**Consultation Response from KC,
Trees**

2023/91441 31, Chapel Hill, Linthwaite, Huddersfield, HD7 5NJ

Change of use and alterations to former church (B8-storage) to 9 residential units (C3) and formation of car park (Listed Building within a Conservation Area)

Date Responded: 09/08/2023

Figure A8.1: Proposals for retaining wall in proximity to T006 and T007

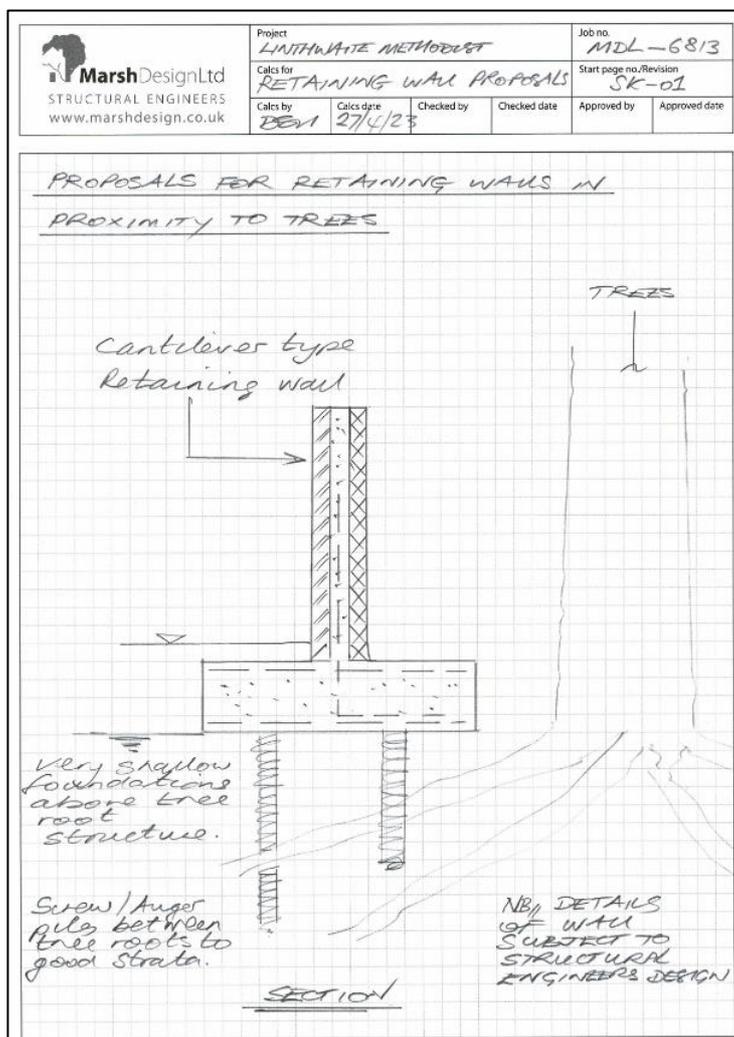
The proposal also appears ignoring the advice from the project arborist regarding the parking area within the Root Protection Areas (RPAs) of T006 and T007, the Sycamore and Ash which are subject to TPO 03/82 detailed in section A3.8 Cantilever Retaining Structure and Elevated Parking/Driveway Platform. To facilitate the parking area while preserving the rooting system and soil structure under it.

This is because the proposed site plan (Drawing P 100) doesn't reflect what is proposed within appendix 6 of the arboriculture impact assessment Ref WC-160.1 revision a by showing the Cantilever Retaining Structure and Elevated Parking/Driveway Platform on the plan. This approach or equivalent like RootBridge® would be tolerable from a trees team perspective if the default position of keeping new structures outside the RPA of retained trees can't be achieved.

Project:	Linthwaite Methodist Church, Huddersfield
Drawn by:	Jack Delaney
Date:	9th May 2023
Scale:	1:100 @ A1
Drawing Number:	WC-160.1a.4

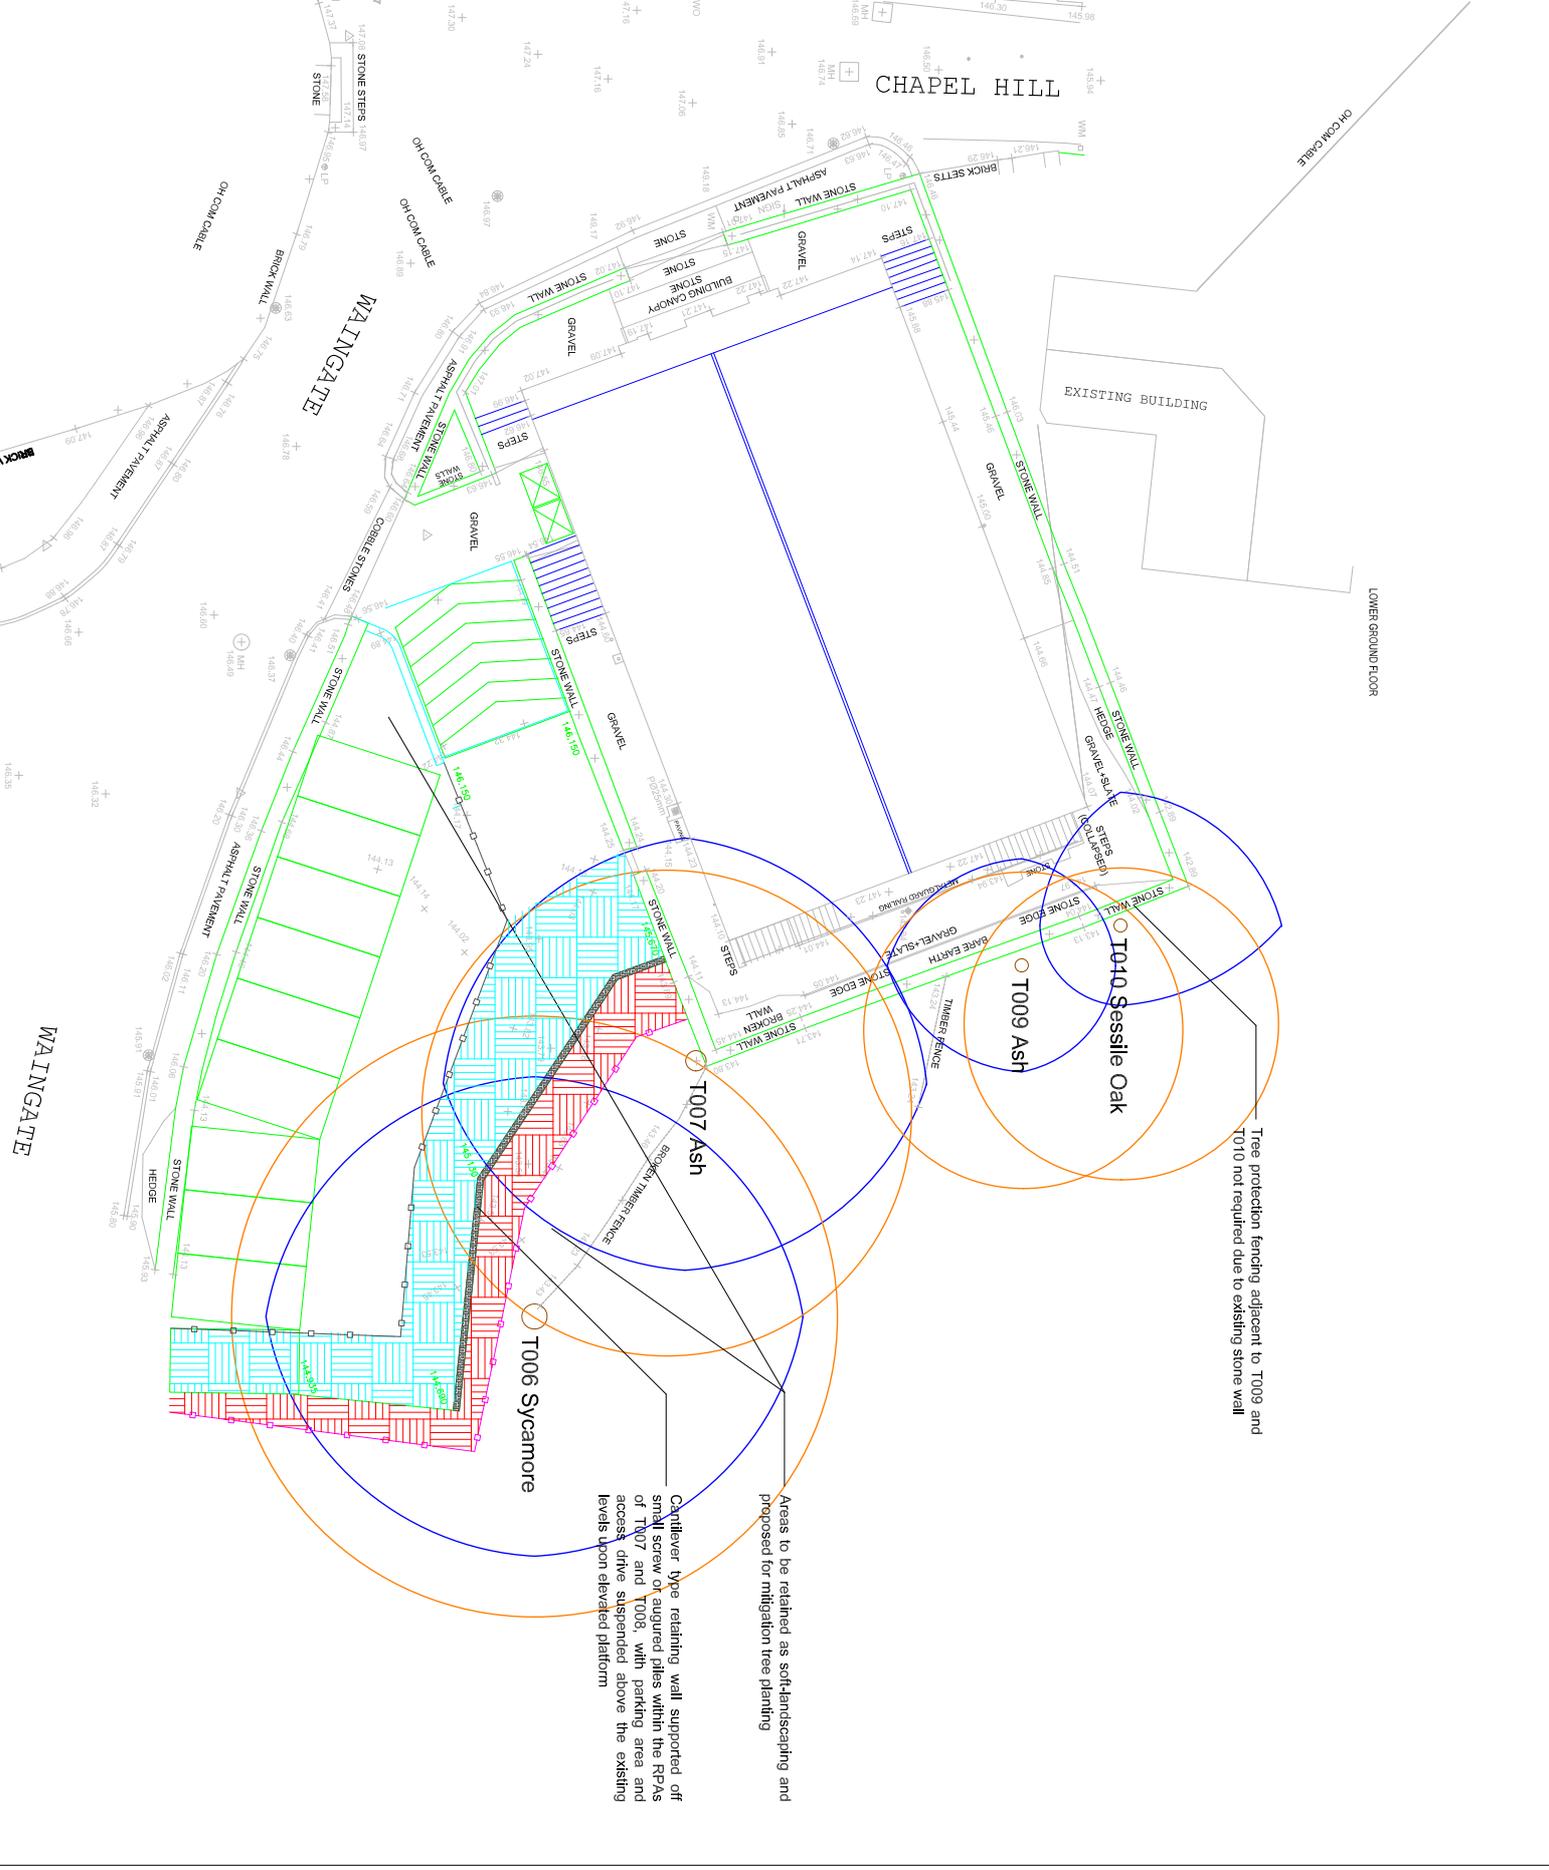
The proposed site plan (Drawing P 100) needs the tree data from the tree constraints plan (appendix 4) of the arboriculture impact assessment Ref WC-160.1 revision a shown on it.
